From: Alison Harvey <aharvey@heritagecouncil.ie>
Sent: Wednesday 19 October 2022 10:10
To: Appeals2 <appeals@pleanala.ie>; Bord <bord@pleanala.ie>
Cc: Alison Harvey <aharvey@heritagecouncil.ie>; Ian Doyle <idoyle@heritagecouncil.ie>
Subject: Planning Reference No. N12162 - Monaghan Urban Regen Proposals

1.0 HERITAGE COUNCIL SUBMISSION - INTRODUCTION

The Heritage Council supports the planned regeneration of Monaghan Town Centre in principle. However, there are several concerns in relation to the proposed development, as submitted to An Bord Pleanála in August 2022. These are set out below under the following headings:

**MGT0528-RPS-
00-XX-DR-C-
SK0013 - ESB
SUBSTATION
(Planning Issue)**

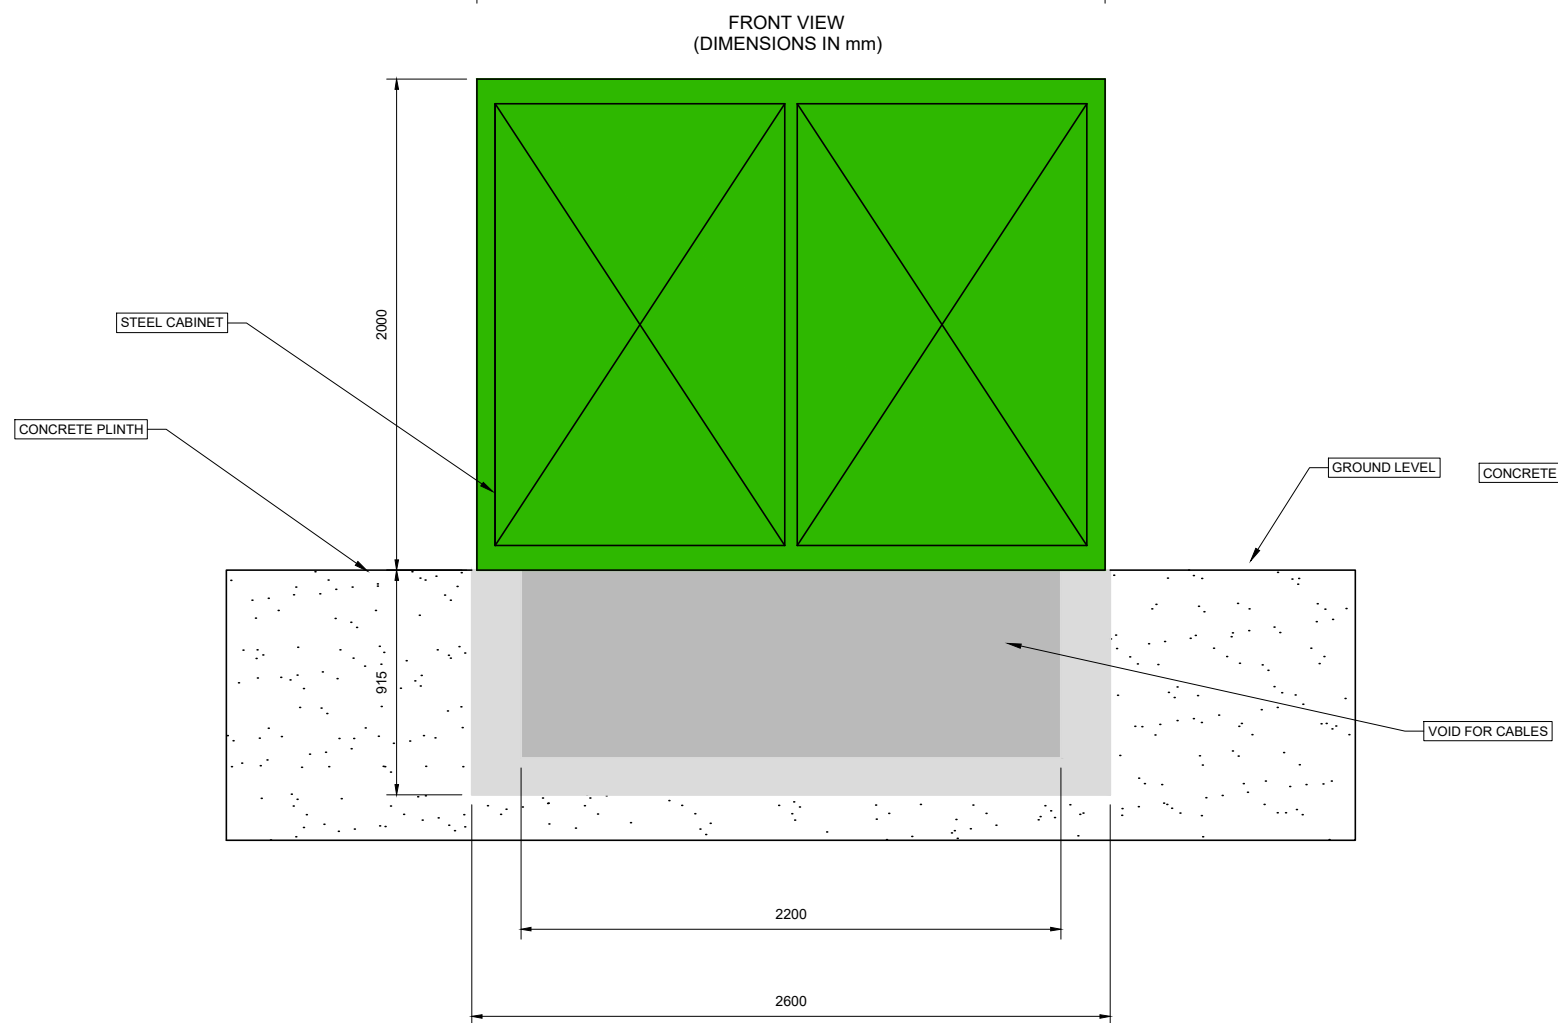
For example, the treatment of the proposed Gavan Duffy Street and new vehicular junction do not adhere to the overall design principles set out in the 2017 Plan, i.e. the proposal does not have any active frontage on Gavan Duffy Place. In addition, there is no detailed design statement to accompany or as part of the EIAR, which means that the proposed materials have no local context or continuum of Monaghan's unique materiality. Principally, this proposal claims to create a 'vibrant public space' and a 'much enhanced public realm' but fails to address the principal ways that this will be delivered, through defining uses, morphology, elevational treatment. The only elevations that are provided within the planning submission is one for a wooden fence beside the 'Northern Standard elevation' and the ESB substation.

Given the importance of this historic street in terms of urban form and fabric, it is submitted that the scheme is a modern car-focused proposal rather than people-focused/human-scale as proposed by the 2017 Plan, i.e. the proposed scheme does little to add to a walkable historic town centre. For example, there is no attempt to provide detail of elevational treatment, other than the gable length treatment of 'Charles Gavan Duffy Place', the 'Northern Standard' which provides for a 'high quality wooden fence' and the front and side elevational treatment of the ESB sub-station.

EXISTING BUILDINGS TO BE DEMOLISHED
Dublin Street No. 08, 09, 10 and 11.

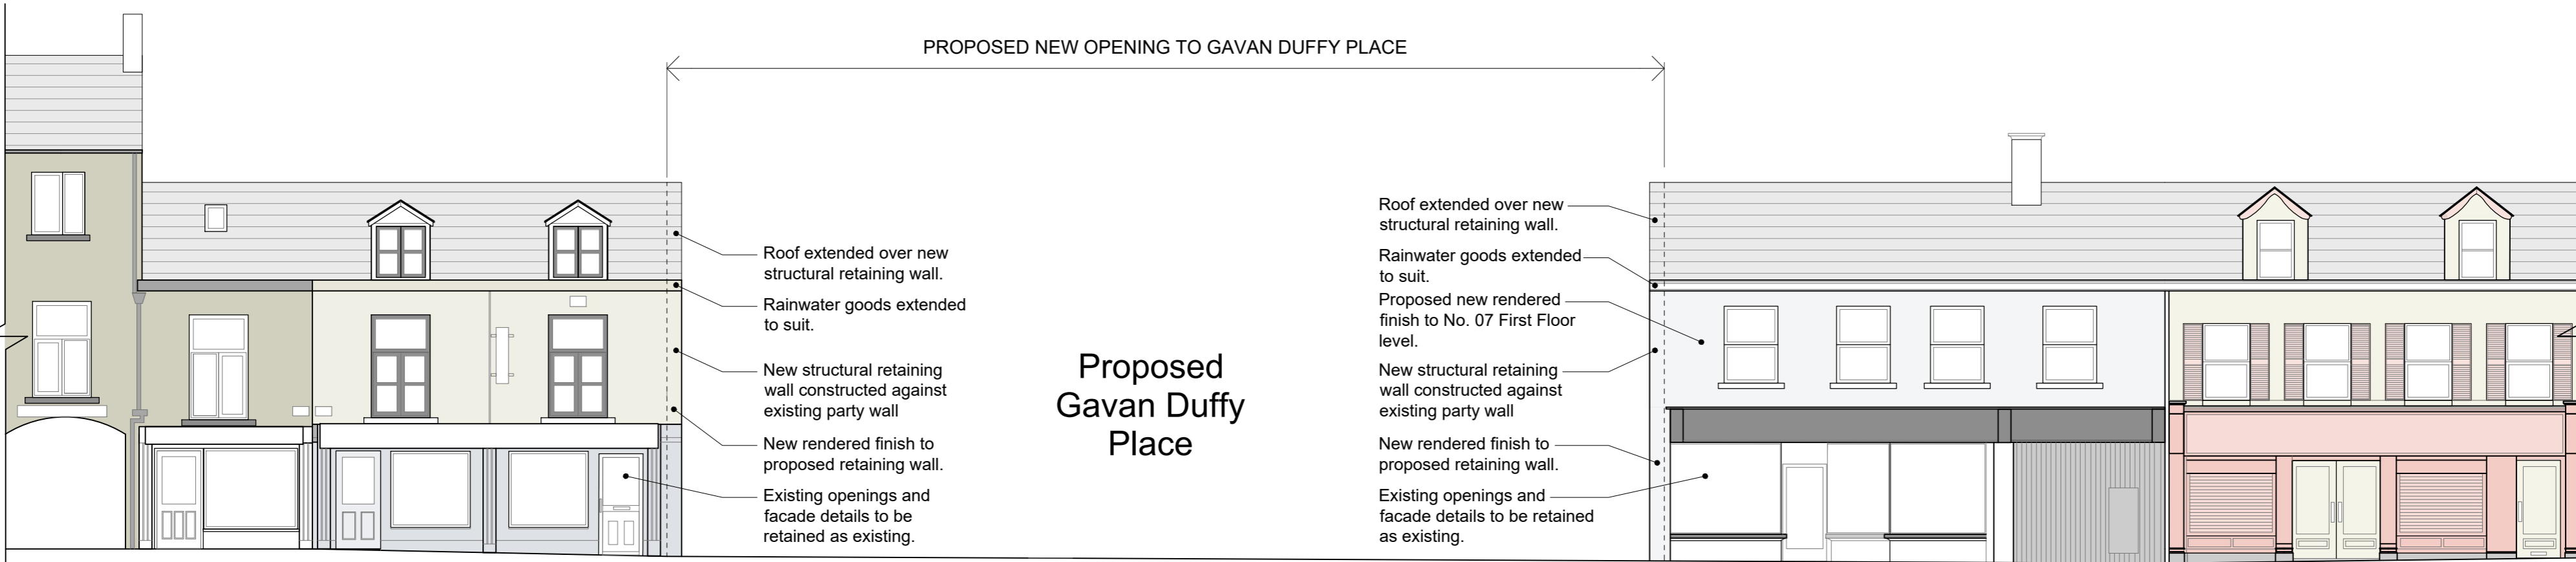
It is recommended that the development proposal be significantly altered to conform to this pattern, and not to break it by the opening-up of a large hole in the street elevation by the demolition of Istanbul, the birthplace of Charles Gavan Duffy and the Best4U shop and adjoining shop and house.

The proposal includes the demolition of four historic buildings that front onto Dublin Street. This is regrettable from the point of view of their historical worth and contribution to the setting of the Dublin Street ACA. They contribute to the very definition of what an ACA is meant ‘to preserve the character of a place, area, group of structures or townscape, taking account of building lines and heights’ (S. 81(1), Planning and Development Acts 2000-2019).
